**Consultation Response from KC,
Lead Local Flood Authority**

2024/91591 Land off, Bankwood Way, Birstall Retail Park, Birstall, Batley, WF17 9DT

Variation conditions 2-6, 15, 29 on previous permission 2021/92528 for erection of retail development, associated parking, servicing areas and landscaping

Date Responded: 05/11/2024

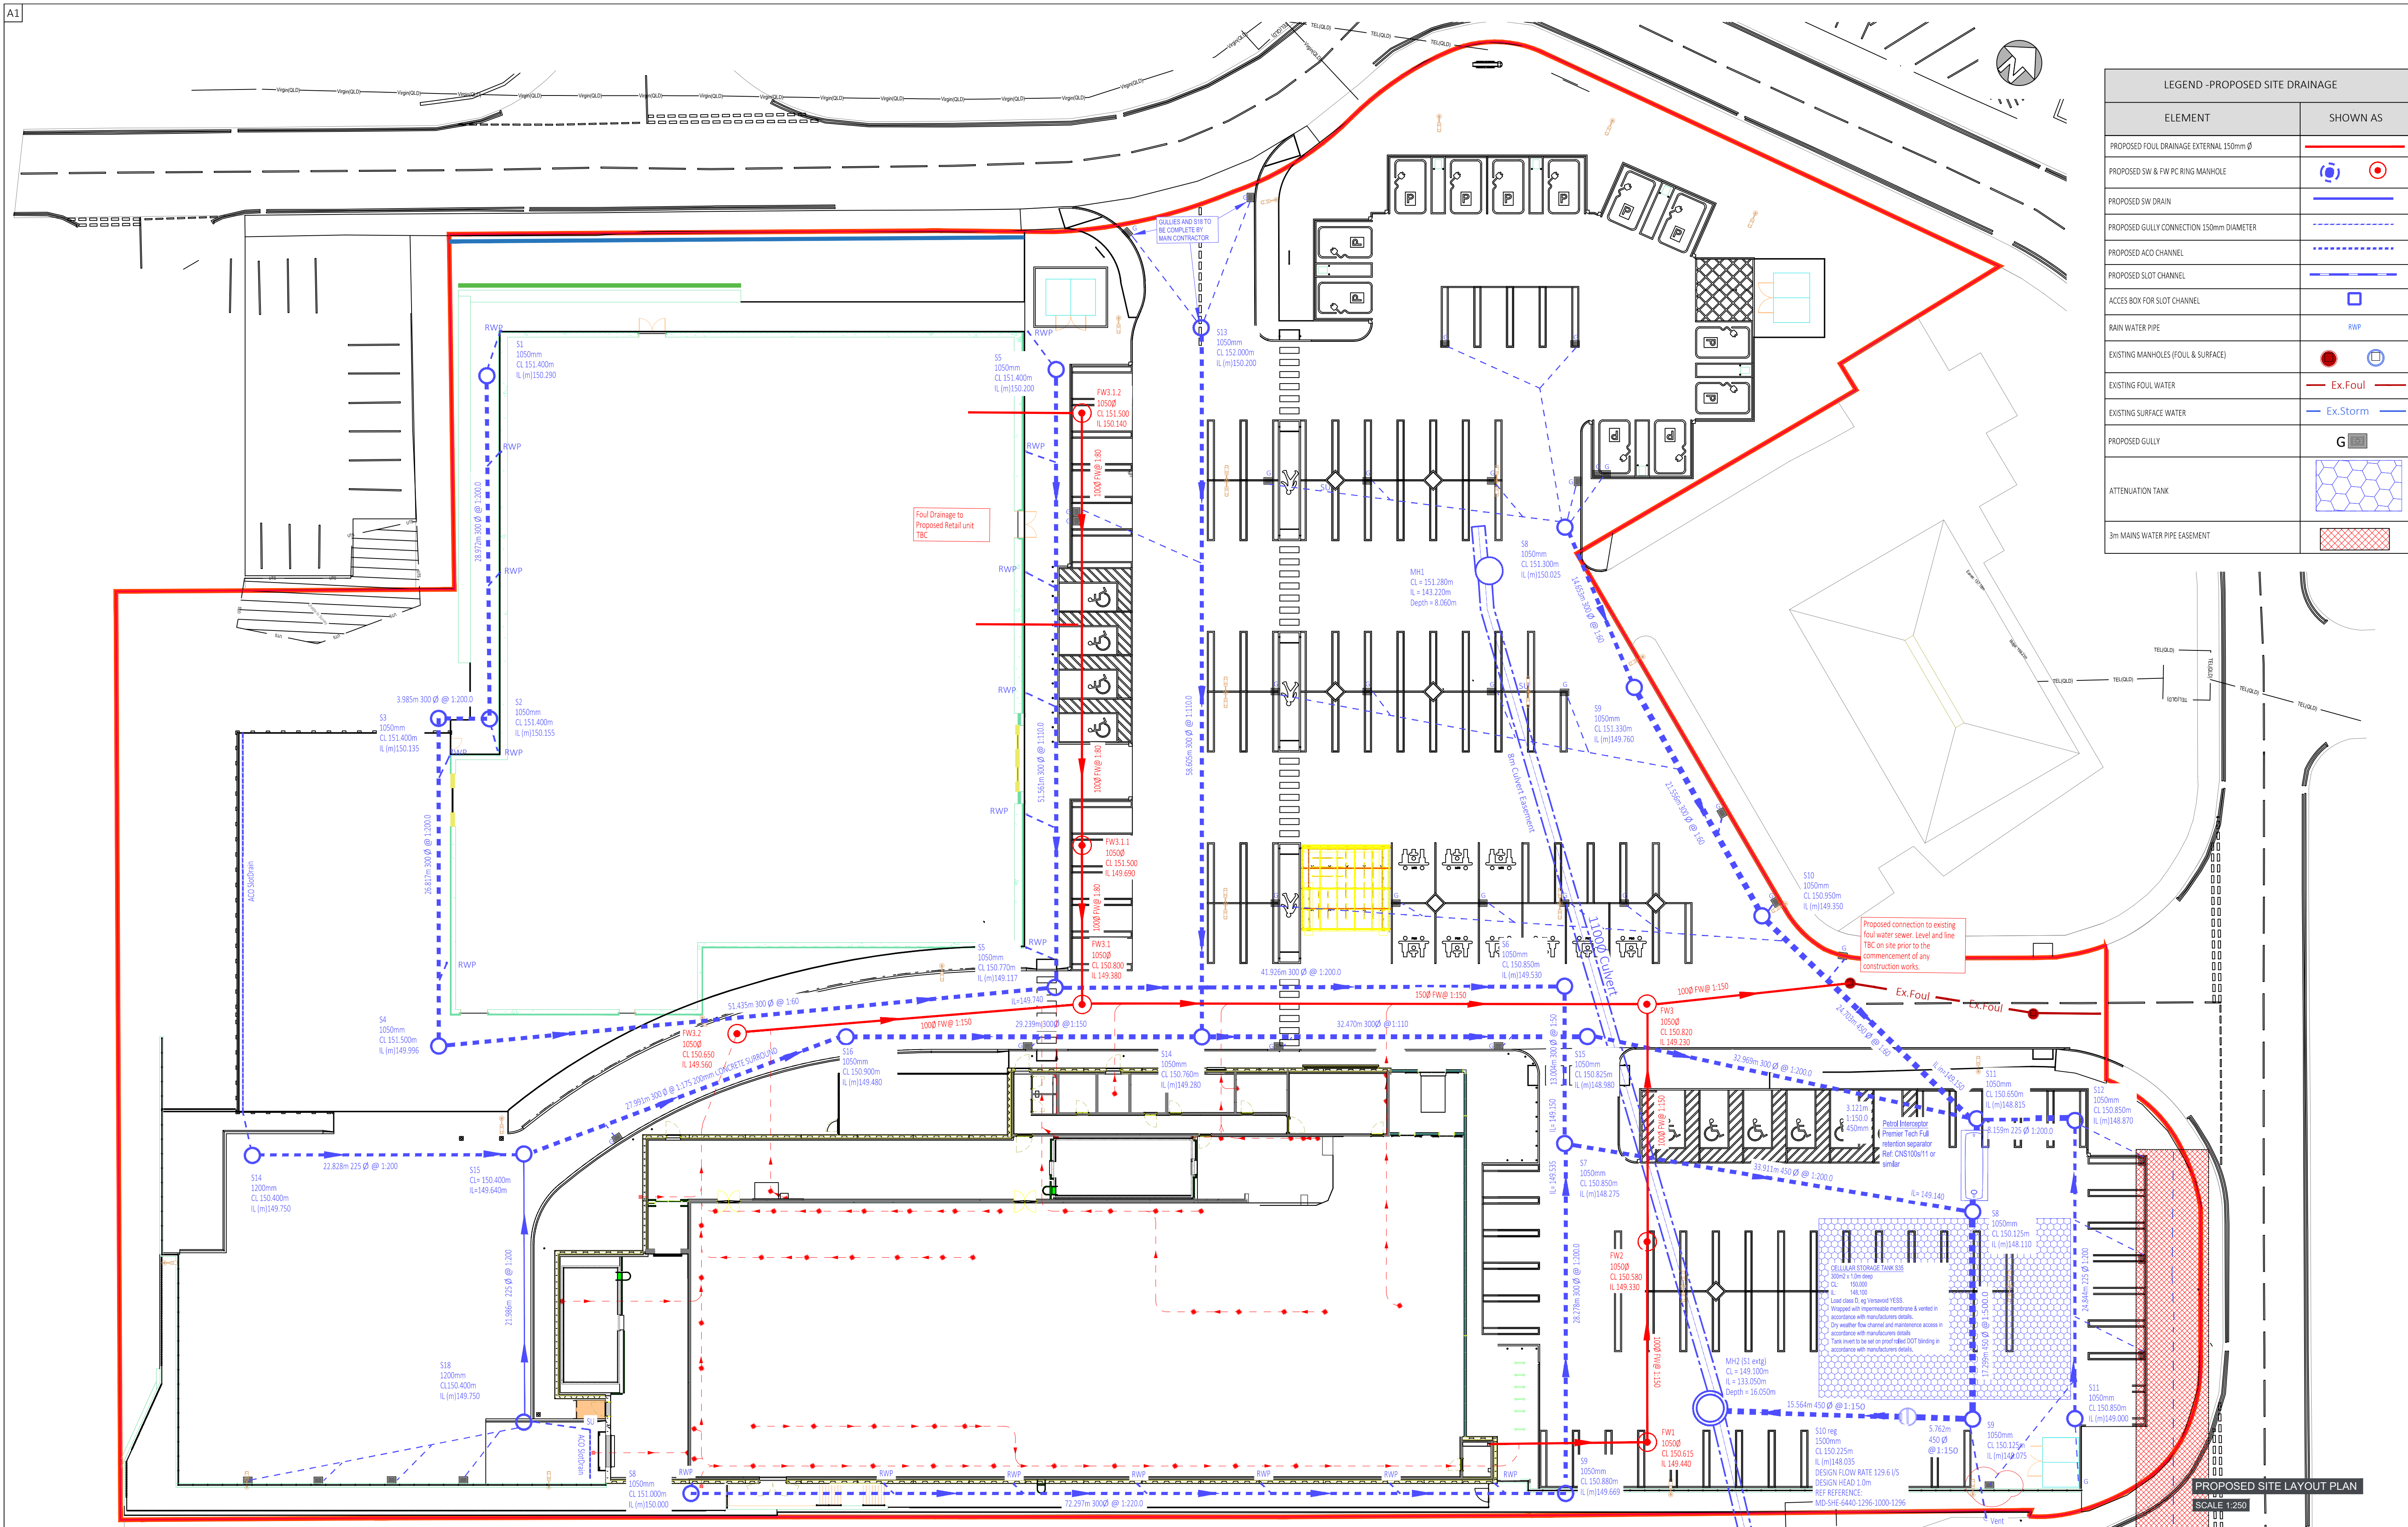
The submitted drawing indicates an oil separator ref Premier Tech Aqua Full Retention Separator CNS100s/11 (or similar) suitable for drained area up to 5556m² serving hard standing areas only. The LLFA confirms that this is accepted and therefore Condition 11 can be discharged.

The LLFA confirms that the proposed surface water discharge rate of 129.6l/s into the existing 1,100mm culvert running through the site and provision of 285m³ (free volume) attenuation storage are acceptable, therefore Condition 12 can be discharged.
